Addendum No. 2

RE: Contract # C203667
WBS # 42271.3.2
STATE FUNDED
Macon County (B-5125)
Bridge #22 Over Little Tennessee River On US-441 Business

October 18, 2016 Letting

LAMP PEDESTAL DETAILS
(★ LAMP POLE & ANCHORAGE TO BE PROVIDED BY OTHERS.)

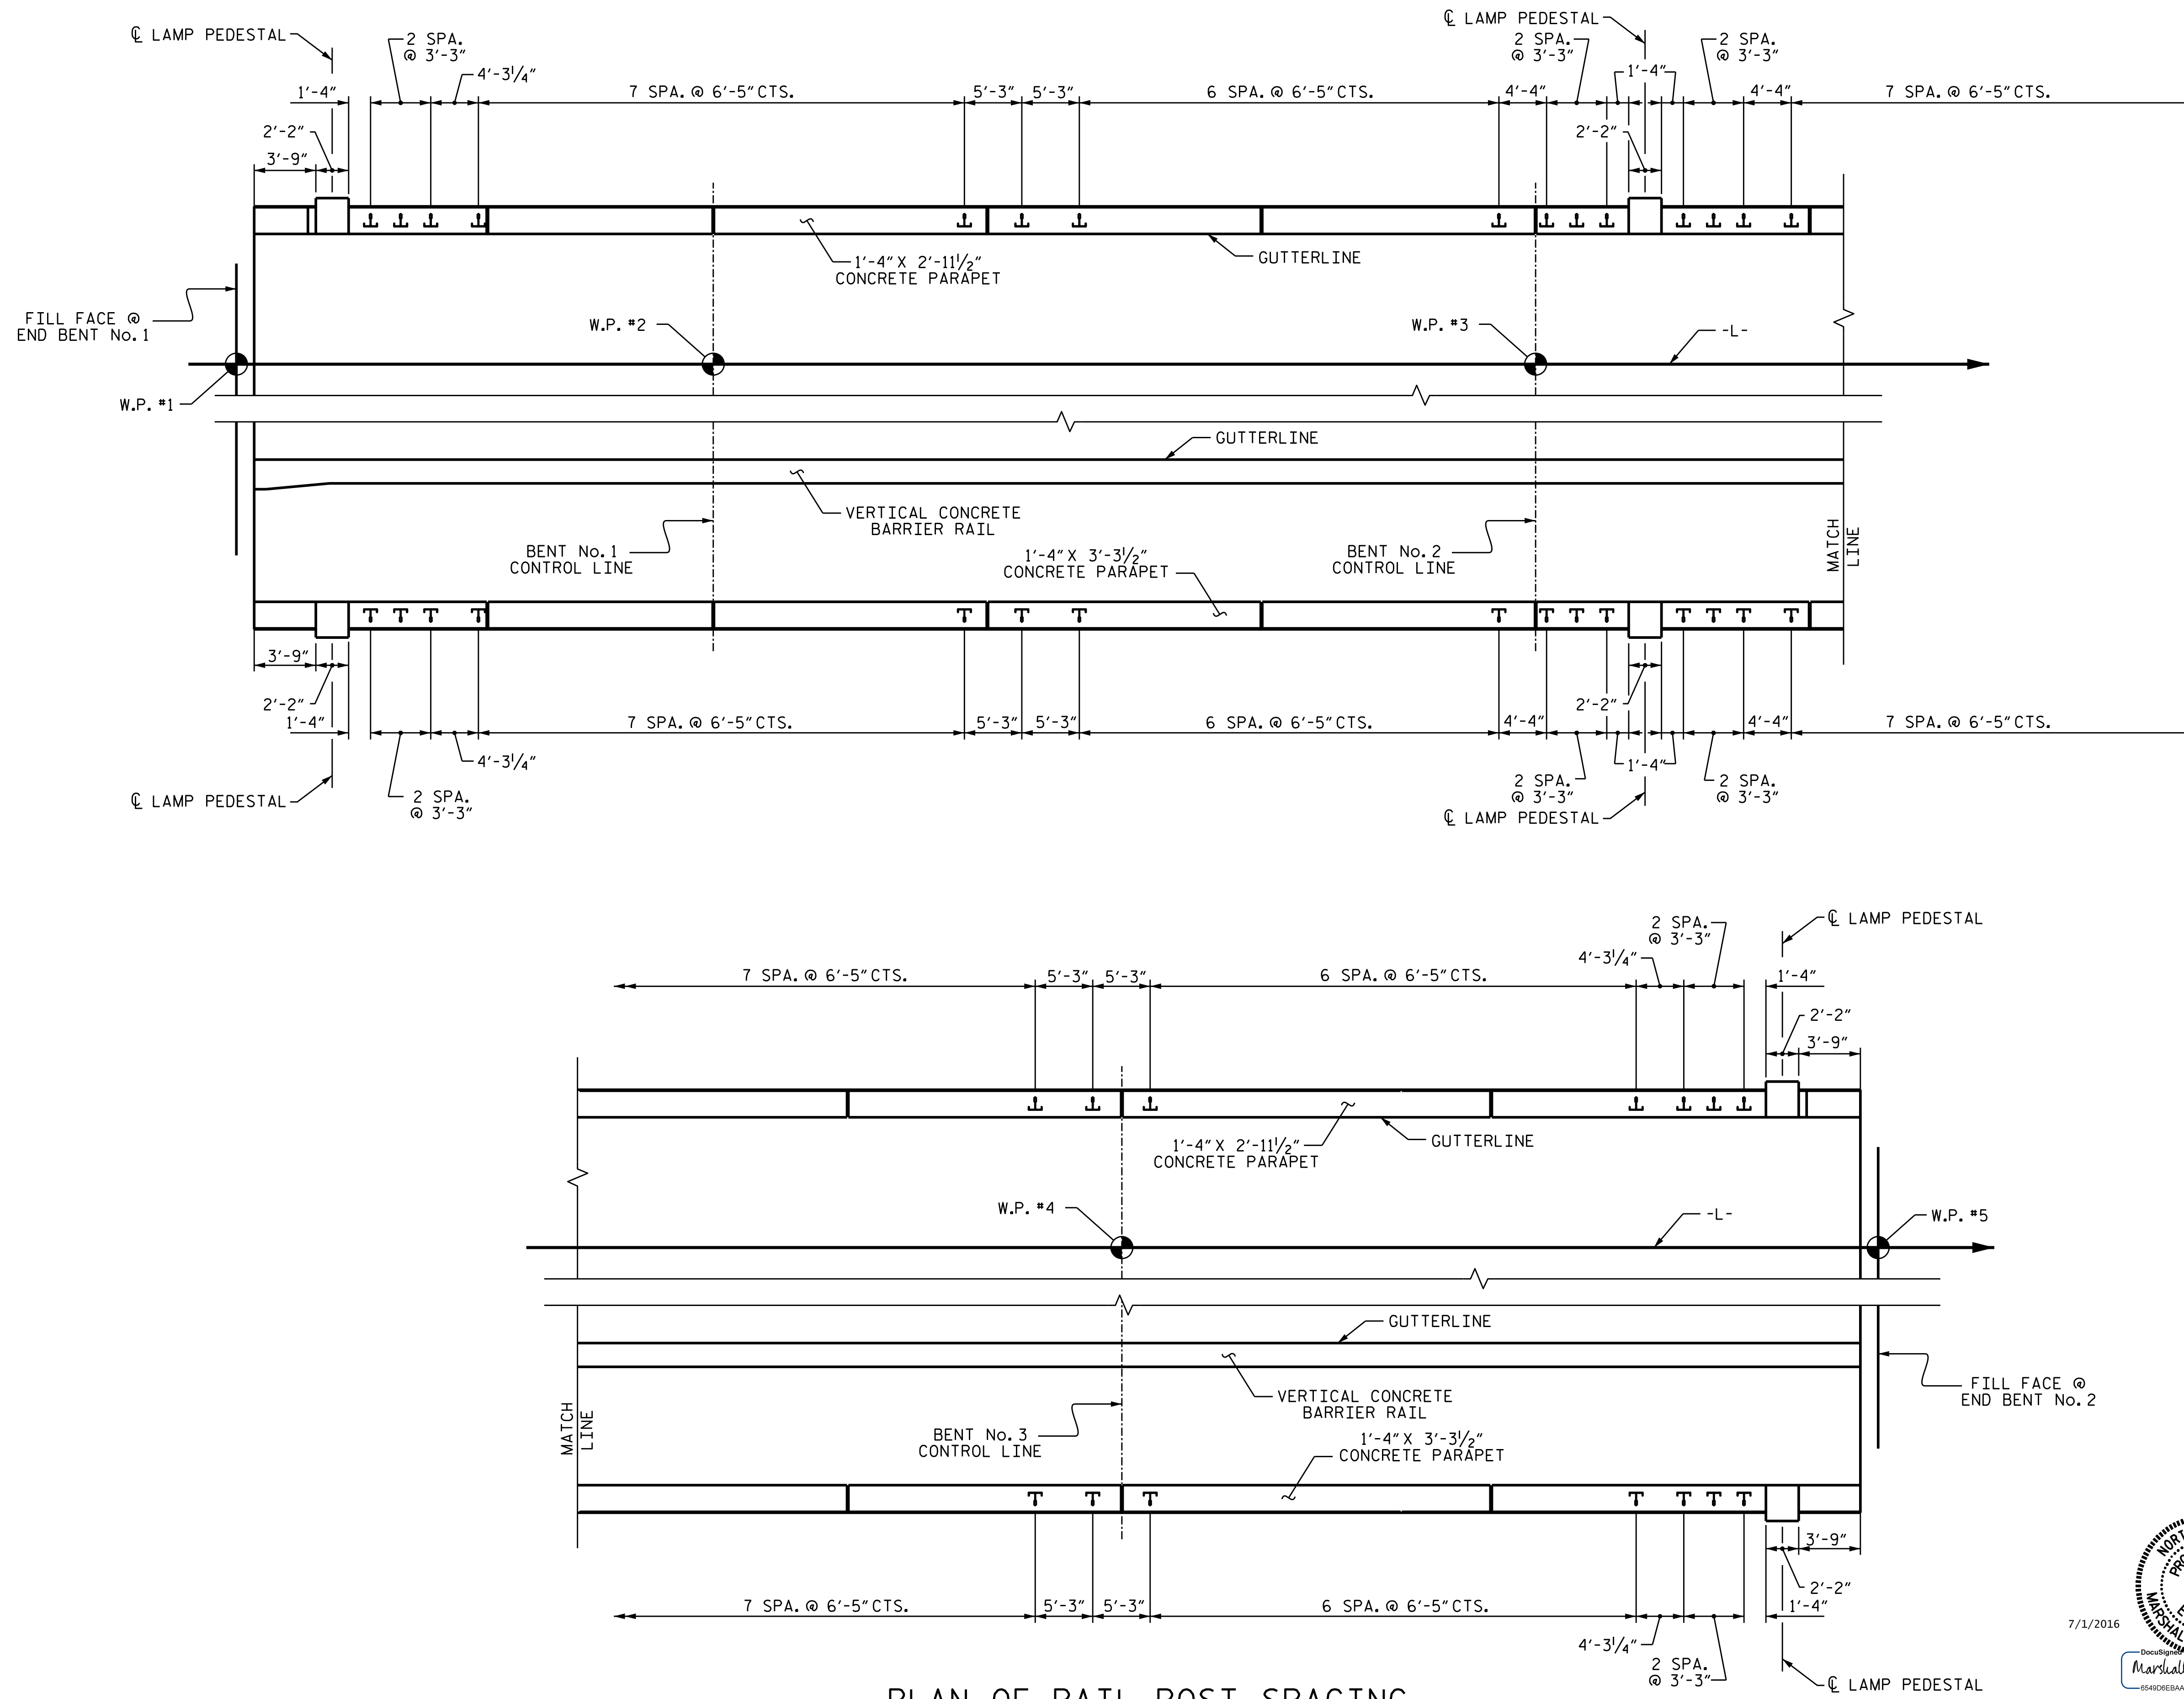
Sheet No.	Revisions
S-40	Revised Notes to clarify anchor bolts are to be provided and installed by others.
